From: Sarah Burrow <Sarah.Burrow@arun.gov.uk>
Sent: 07 May 2021 11:21
To: Planning.Responses <Planning.Responses@arun.gov.uk>
Cc: Simon Davis <Simon.Davis@arun.gov.uk>; Laura Gibbons [REDACTED]
Subject: BN/41/21/DOC (Tars Farm) Engineers Consultation

Engineers Comments Regarding Surface Water Drainage

Drawing Status	PRELIMINARY
Client	Paul Voller
Project	Tars Farm House, Church Lane, Barnham, PO22 0DB
Drawing Title	Proposed Drainage Strategy Preliminary Design
Scale	1:200
Date	05/02/21
Drawn By	MJA
Checked By	MJA
Drawing No.	D1946-PL300
Rev.	A

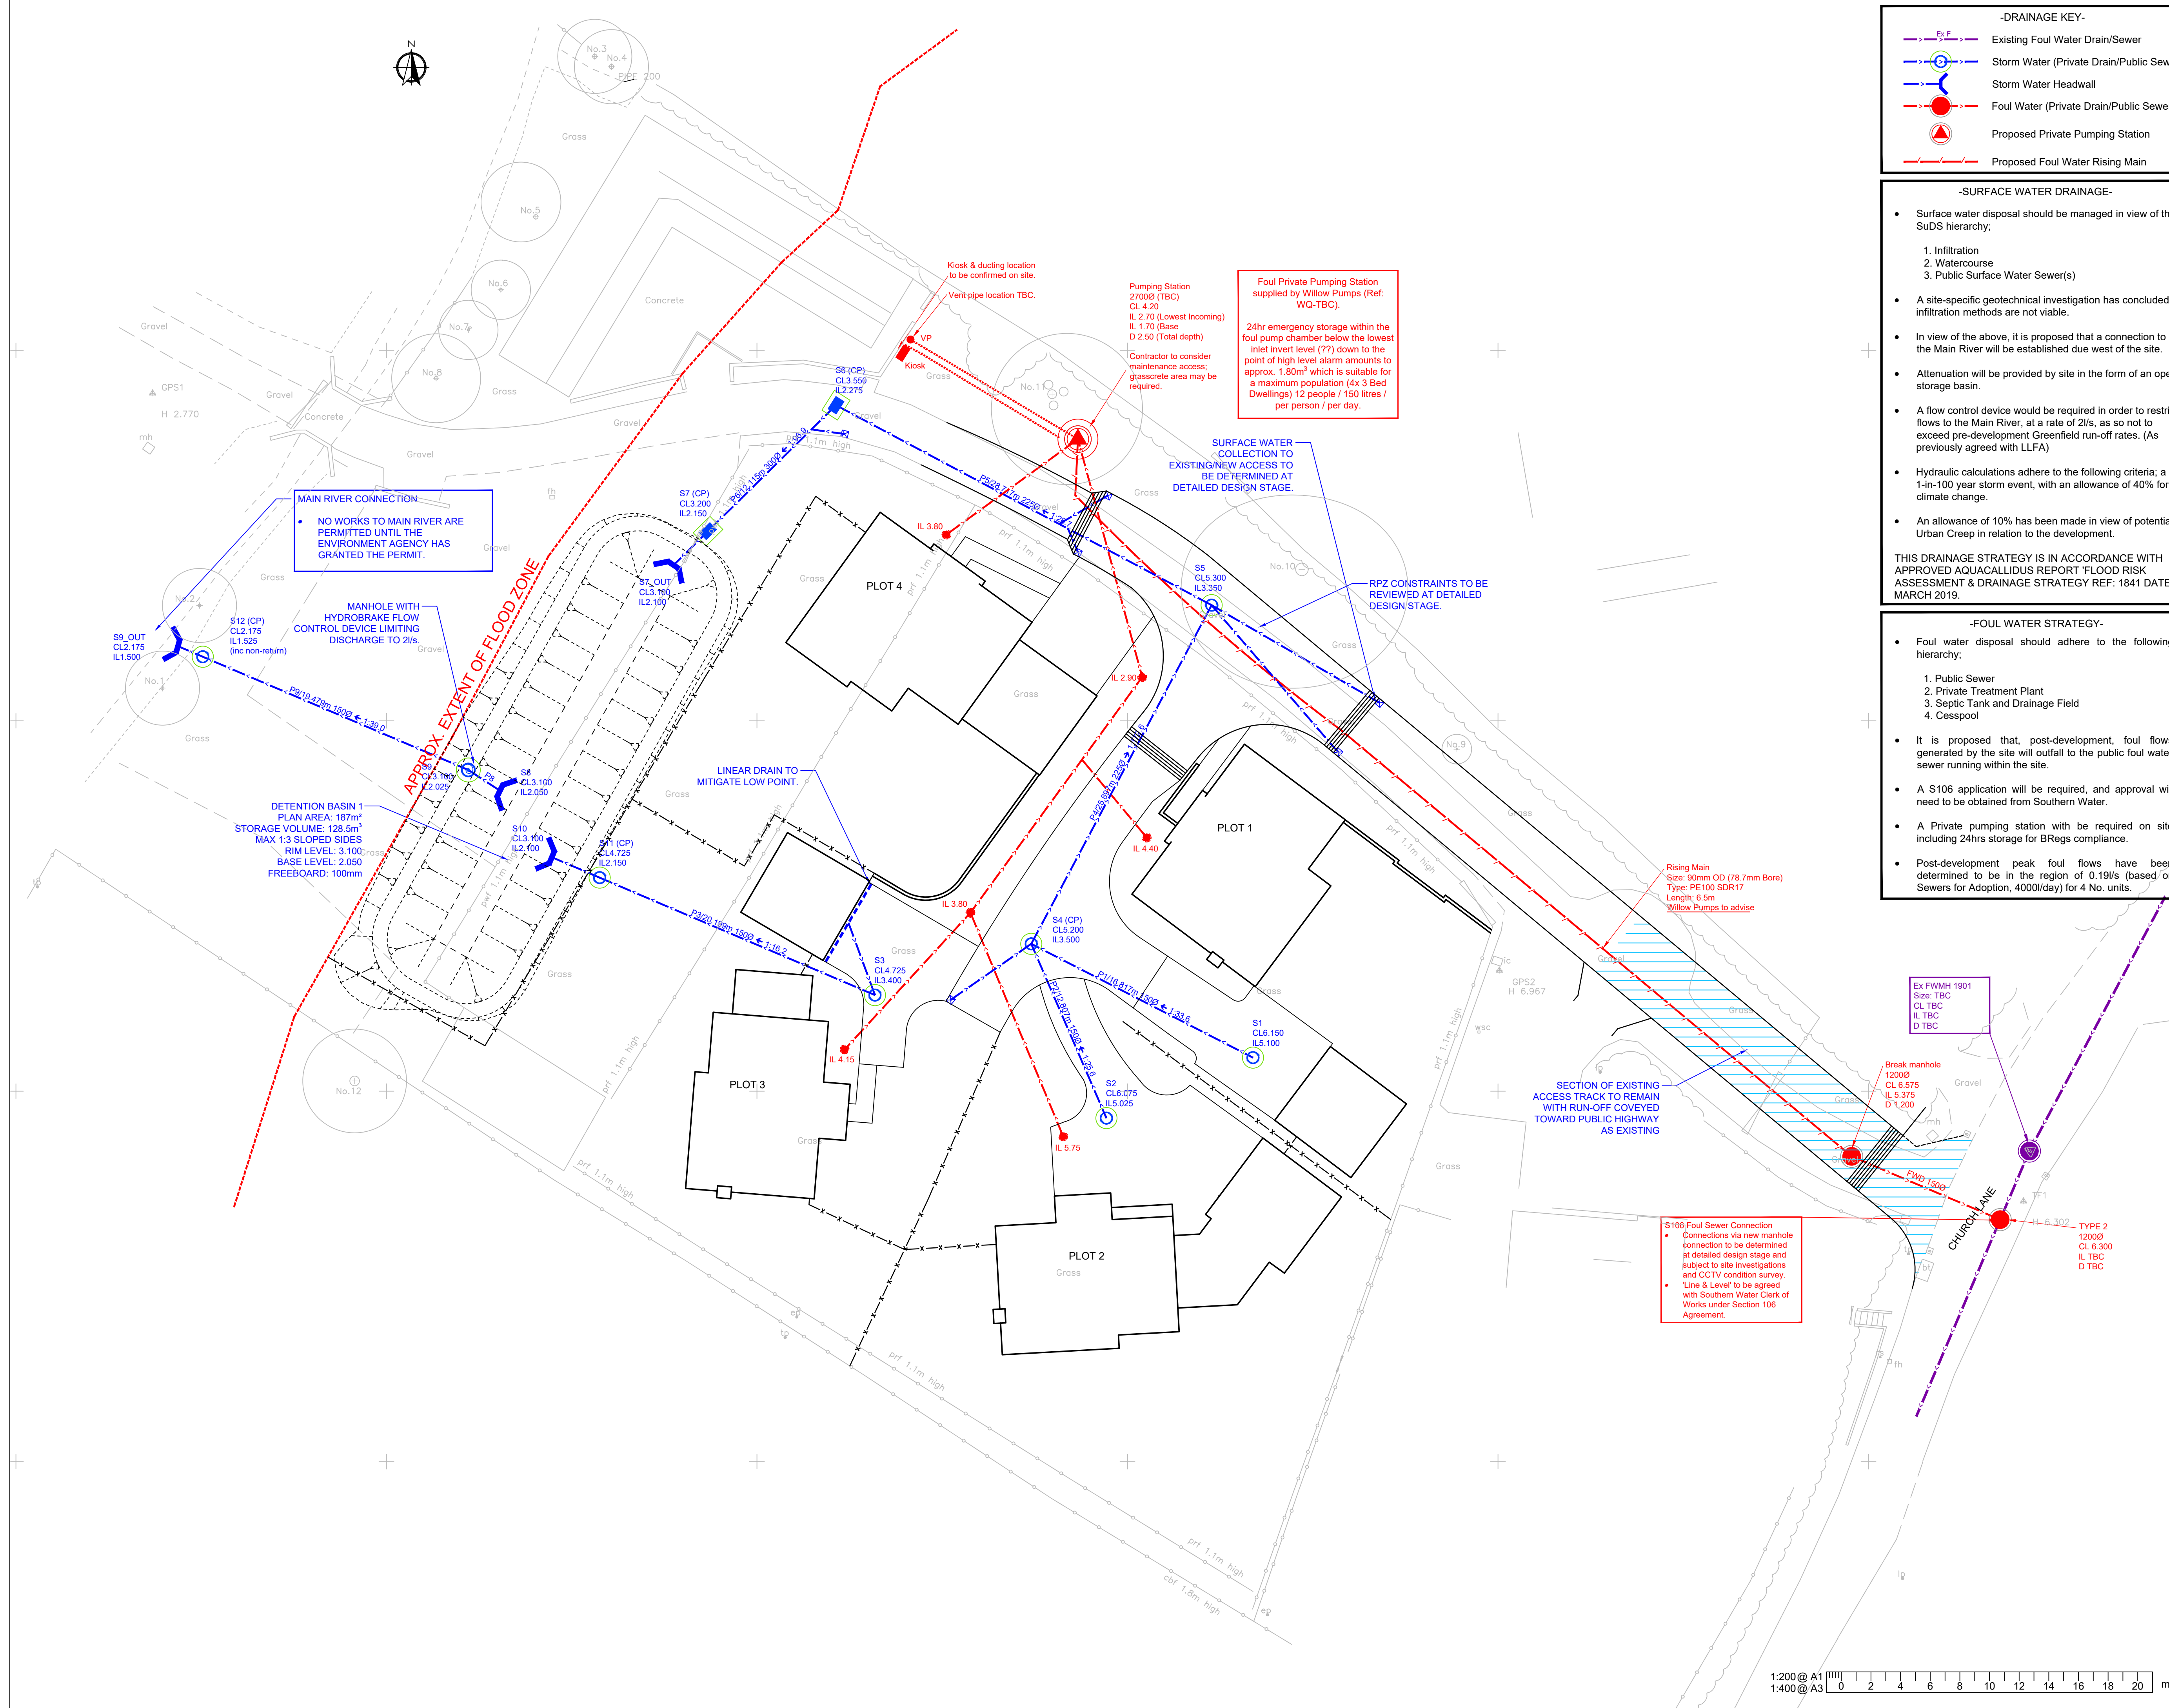
4. The drainage layout shows four pipes connecting with inspection chamber S5 within a tree root protection zone. Please relocate the inspection chamber and pipes to avoid the zone.

5. Please include a list of cover types for each manhole on the layout if each manhole is not individually labelled. It would also be helpful to label each manhole with the appropriate type to correspond with the construction detail drawings.

6. Please label sump depths or sump levels where they are provided on the drainage layout.
7. Please label Hydrobrake flow control with it's product number and design head on the drainage layout.

TYPE A HEADWALL - GRP HEADWALL
OUTFALL TO WATERCOURSE
CROSS SECTION
(Scale 1:20)

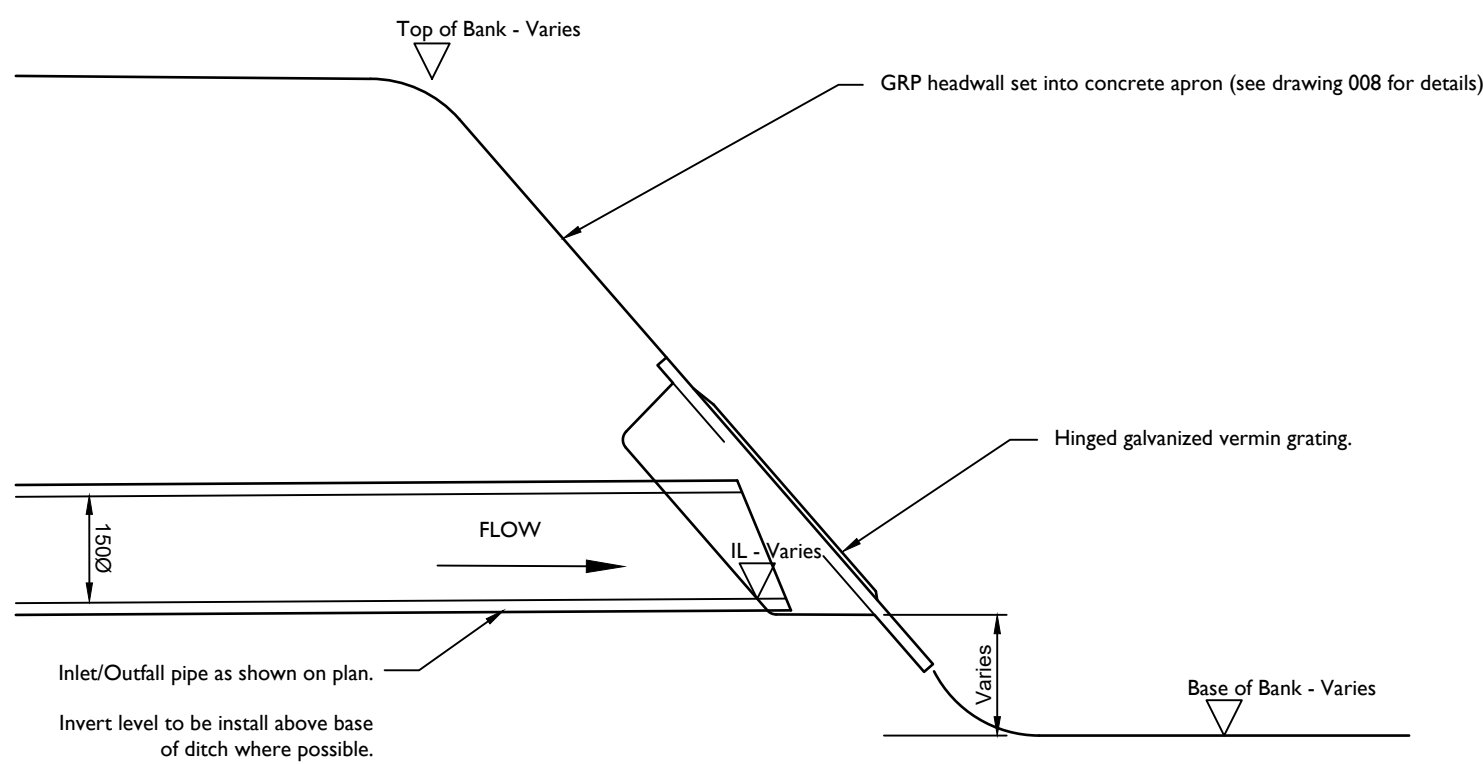
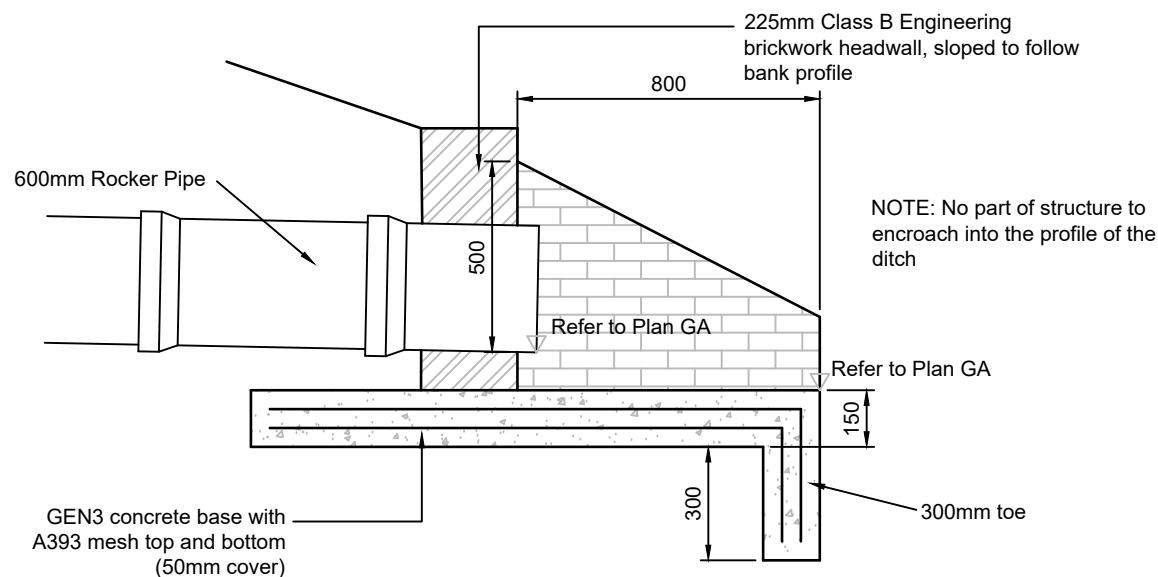
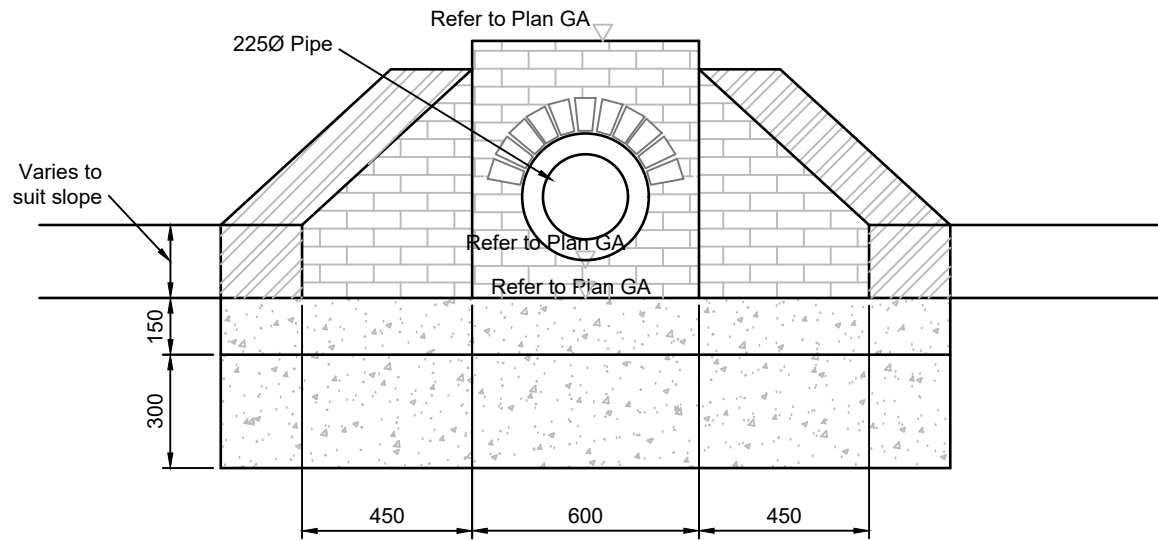
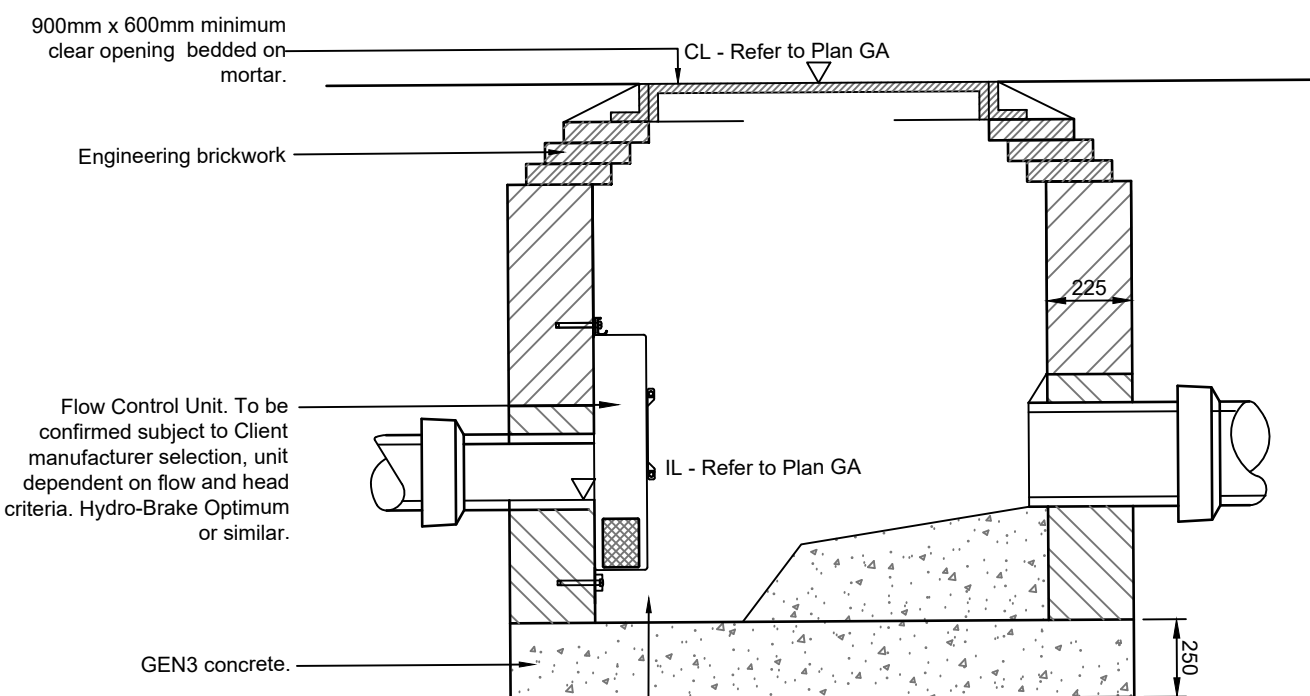
11. Please provide an elevation drawing of the GRP Headwall. Please show all pipe inverts at headwalls to be at least 150mm above the bed of the watercourse/basin.

12. Please label the headwalls (type A or B) on the layout. It would be helpful to tabulate the hard bed, soft bed and top of bank levels for the different headwalls with the construction details (rather than provide an individual detail for each one).

Refer to flow control manufacturers details for Sump dimension.

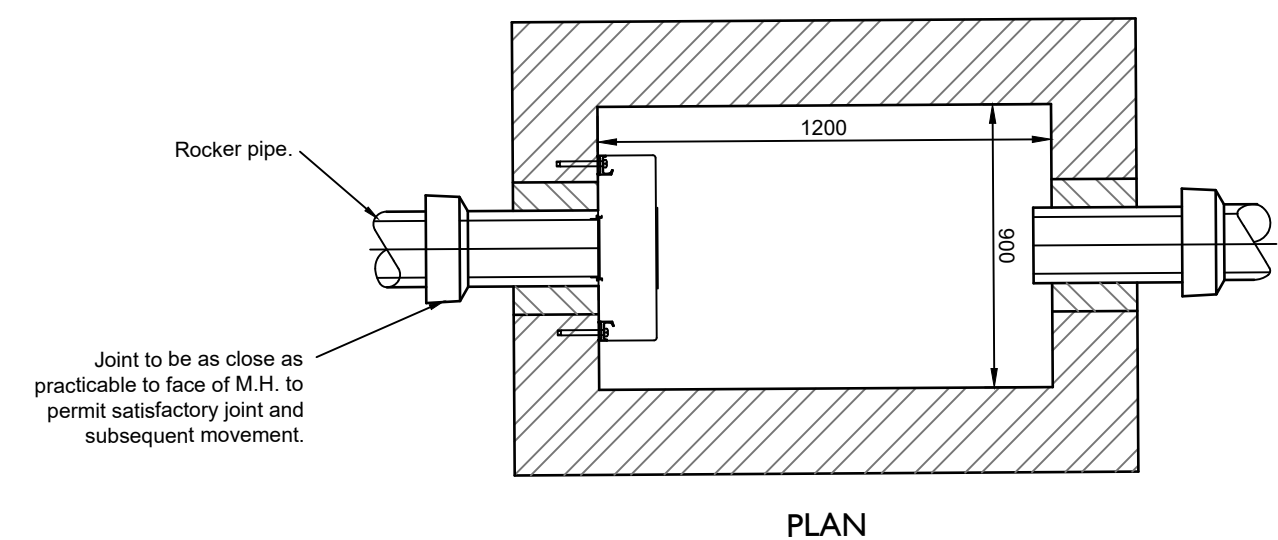
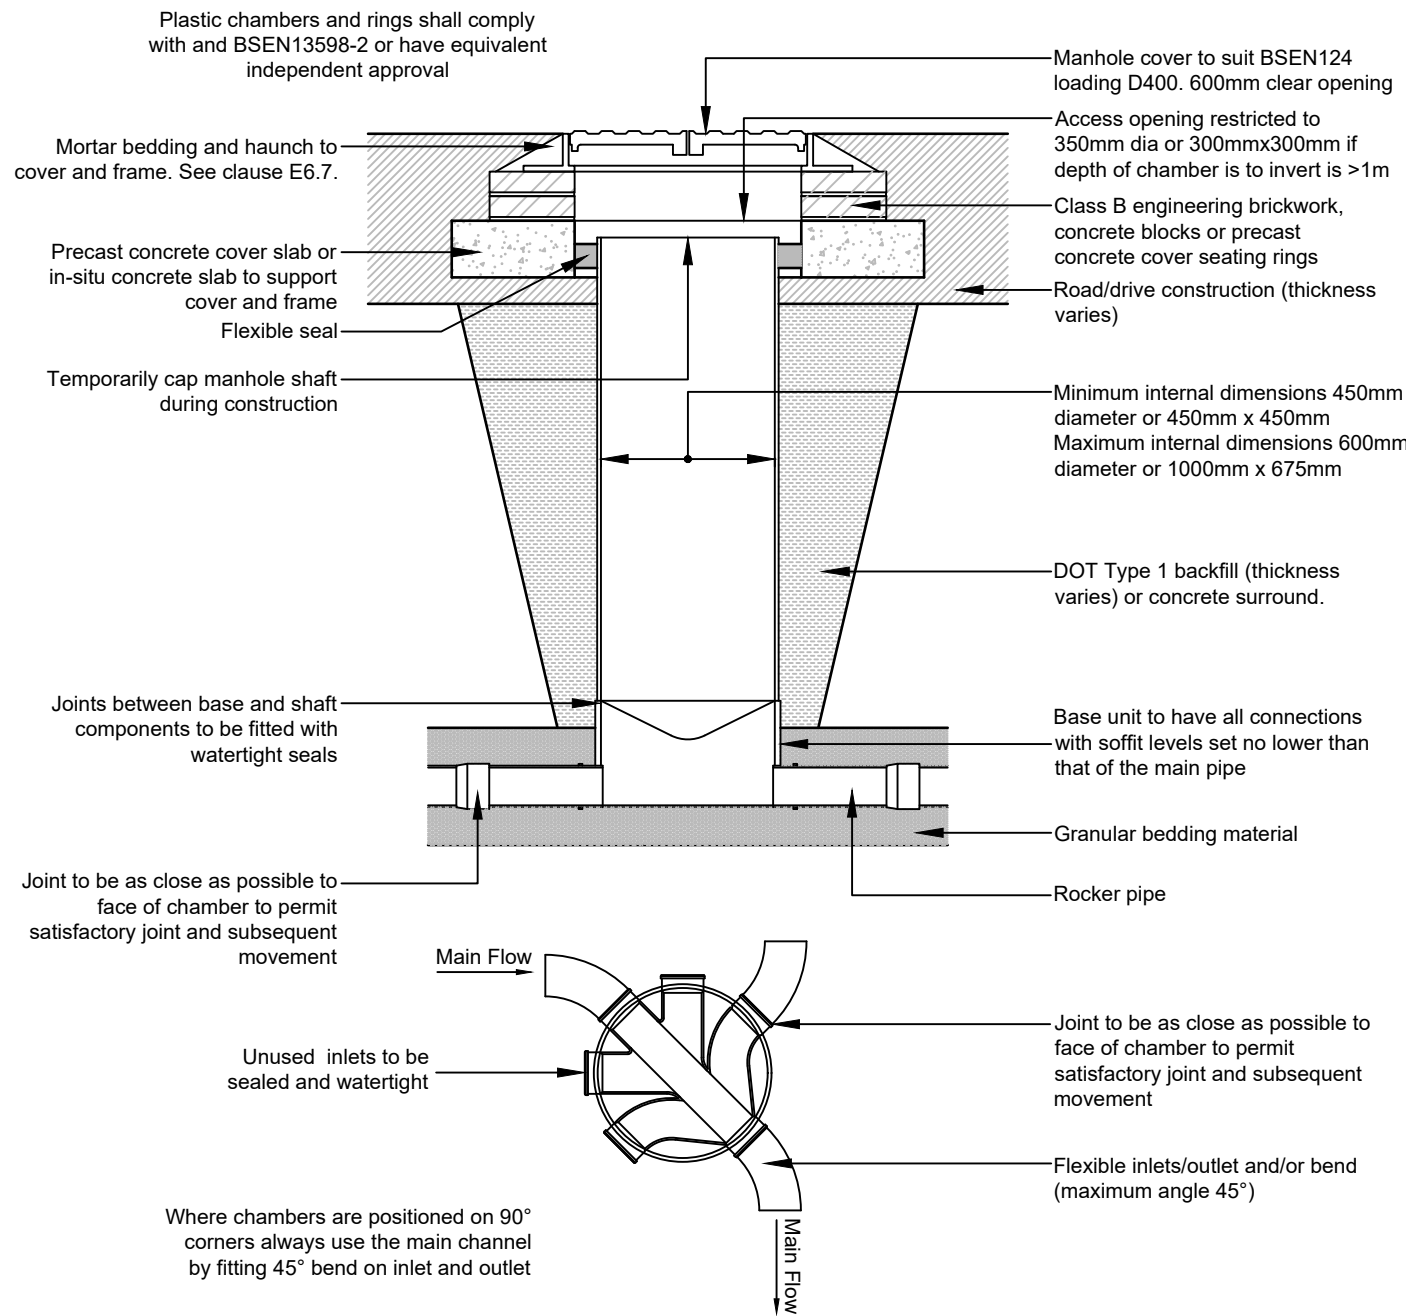
9. Please show overlaps and jointing requirements of the impermeable liner on the construction details.
10. Please provide a site specific construction detail drawing of the Hydrobrake flow control device. This should include the product number, invert level, cover level, incoming and outgoing pipe diameters, step rungs and pull handle.
